RE: Cherry Creek Crossing Lot 111 Grading and Erosion Control Plan, El Paso County, Colorado (Kiowa Project No. 14028)

**CDR-17-003 Cherry Creek Crossing Grading and Erosion Control Plan
Review 4**

SC-7

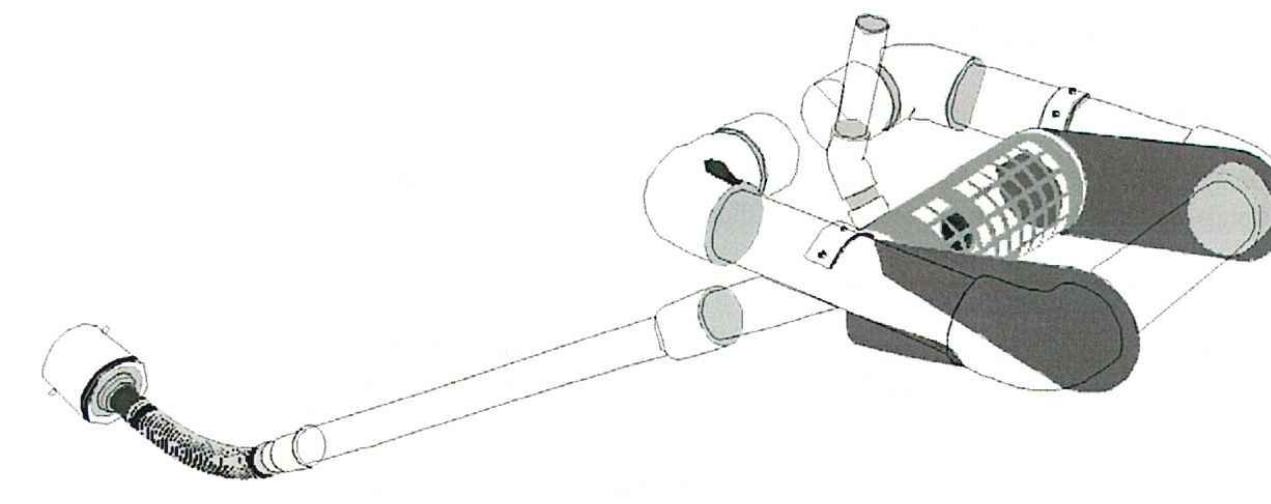
Sheet 8: detail SC-7 deleted from the work.

**CHERRY CREEK CROSSING, FILING NO. 1 LOT 111 OVERLOT GRADING and EROSION CONTROL PLAN**

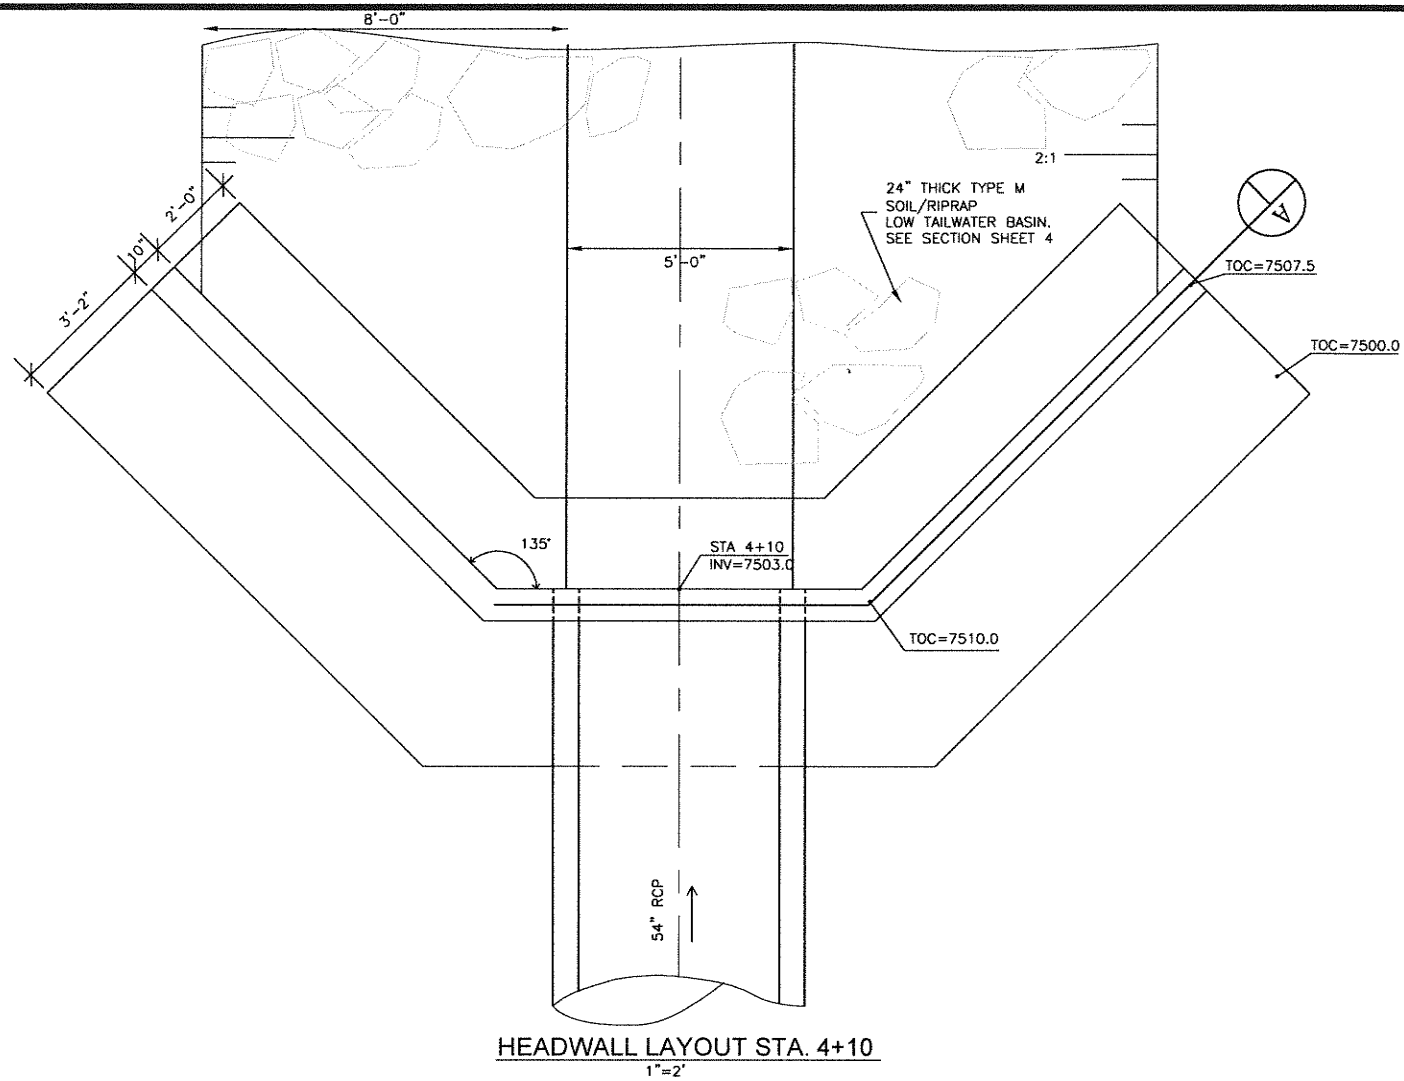
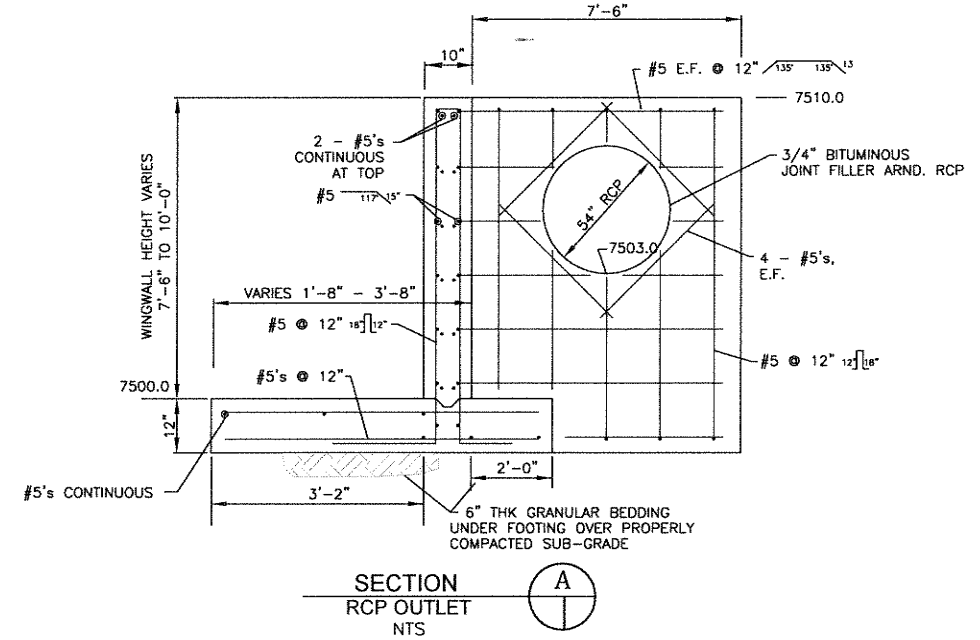
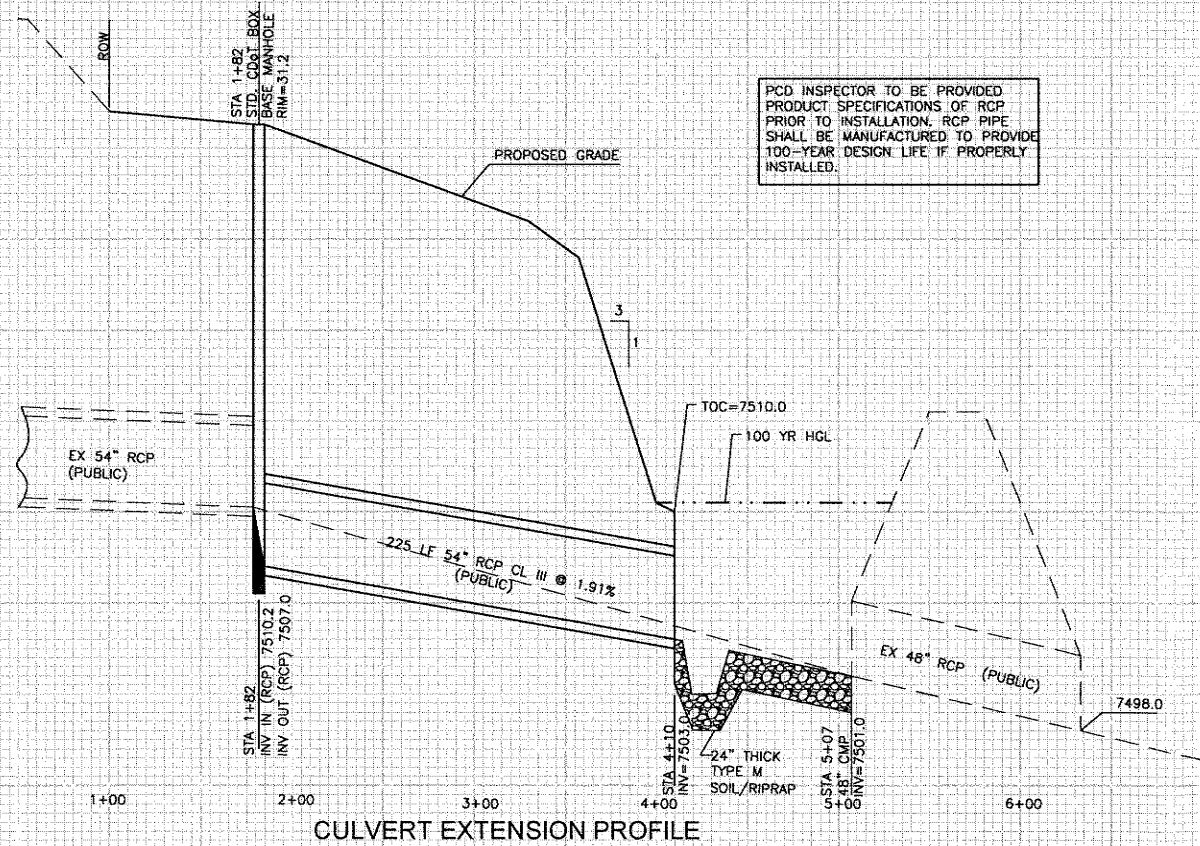
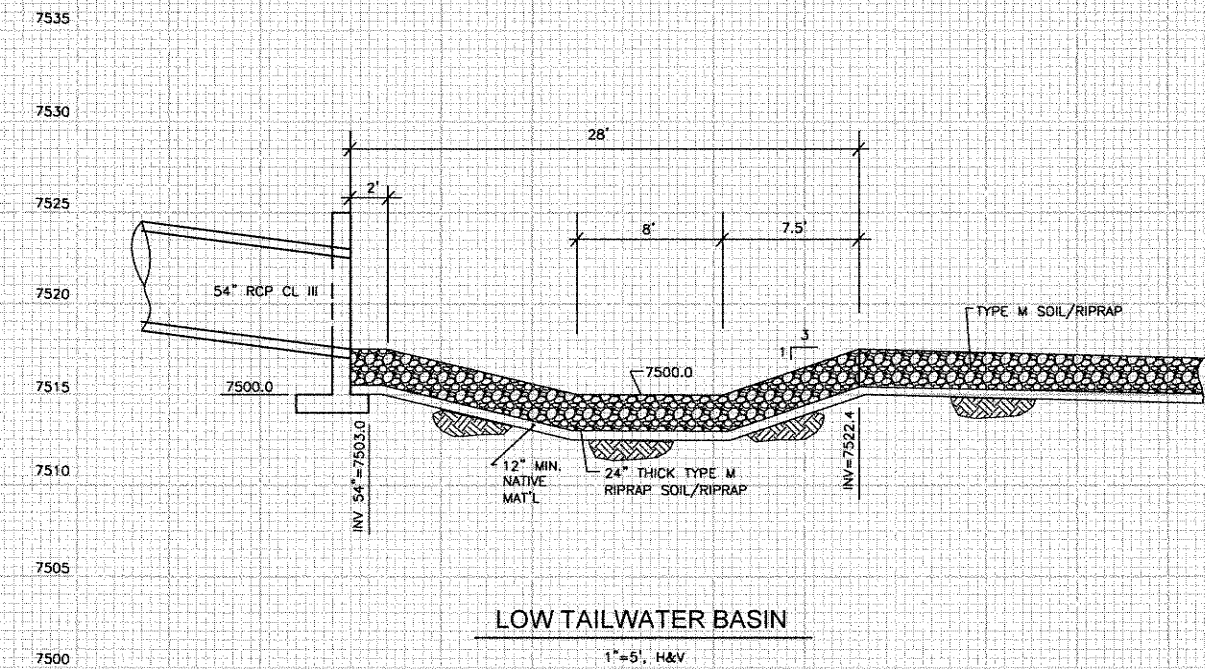
Comment requesting separate plan sheet for improvements to Hodgen Road was discussed with the reviewer. Hodgen Road was overlain and restriped in Spring 2018. As a result, it was agreed that no further design action is needed at the entrance to Lot 111 off Hodgen Road.

Sheet 2: No-build easement has been added to this sheet. A legal description and exhibit have been prepared for this easement as requested and is attached to the draft private maintenance agreement as Exhibit B.
